Project	Application 2024/1060 – Alterations to existing car park and provision of new public open space and landscaping with associated works - Lower Car Park, The Seam, County Way, Barnsley	Document No	159592-002-01
Subject	Technical Note – Response to Highways Development Control Comments of 6 February 2025

BMBC Highways Development Control Consultation Response dated 6 February 2025

3.2 Vehicular Tracking

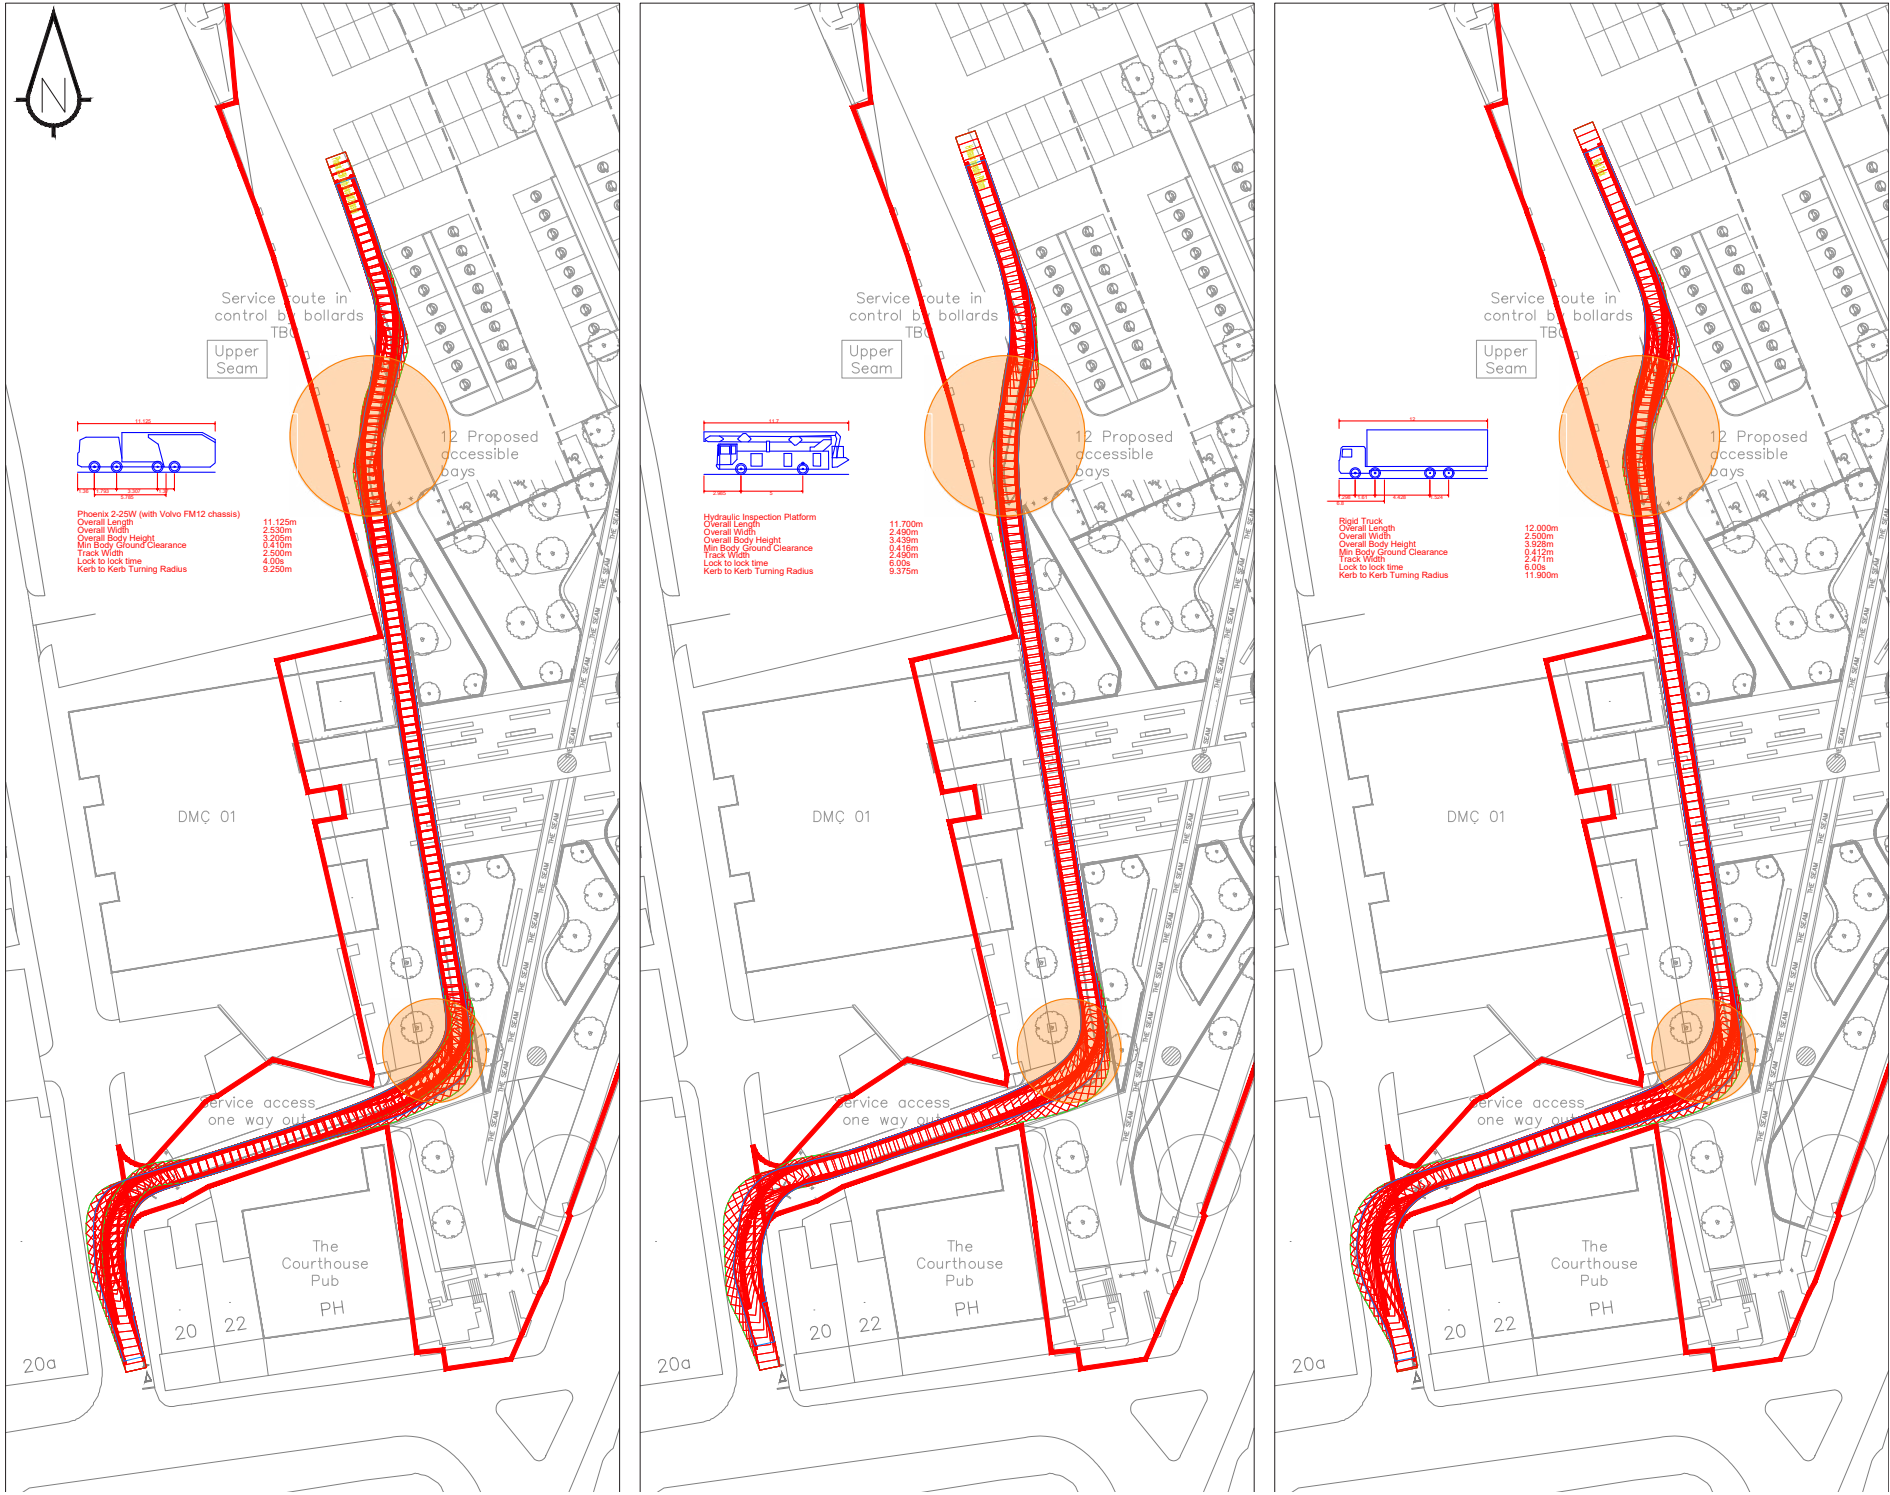
Section 3.2 – Vehicle Tracking has only been provided in the DAS in the form of 3 viewports on page 15 showing swept paths from the car park via the one way system which do not appear to be to scale. There is a need for the vehicle tracking plans to be provided for the relevant design vehicles at a suitable scale for review and this should include the area of one way within the car park to demonstrate that this route can accommodate the requisite movements within the scheme.

Notwithstanding this however, the paths shown on the small viewports appear to show vehicle overhang / overrun along the route. Furthermore, the left turn out onto County Way shows significant vehicle encroachment into the opposing lane. Given that the stop line for the traffic signals is set back from the give way shown, the vehicle design vehicles are likely to be stationary impeding the free flow of vehicles travelling in the opposite direction which is not acceptable.

Attached at **Appendix B** is **Drawing 159592-001 Rev B** which demonstrates the vehicle swept path of three different vehicle types which are anticipated to require access to this area in the future.

One of the vehicle types assessed is a 16.5m long articulated vehicle and although it is understood that such a vehicle does not currently visit any of the premises served by this service route at the present time it is considered prudent to ensure that if such a vehicle does require access in the future that it can be accommodated.

It is noted that there is some minor vehicle overhang into adjacent feature paving/grassed areas along the route. However, in these locations the edge treatment consists of a kerbline with typical kerbface dimension of 100mm/125mm. As such there will be no direct conflict between the vehicle body and the edge restraint.

This situation is acknowledged, however, it must also be acknowledged that servicing by larger vehicles already takes place to the DMC building and the Courthouse PH with large vehicles and as such the same manoeuvres already take place. The presence of HGV's in this area is infrequent and it is not envisaged that there will be any significant change in the foreseeable future.

The development will, however, present an opportunity to improve the situation by making the service route one-way towards County Way and thereby removing potential conflict with other vehicles which are currently able to access the Lower Seam car park from this point.
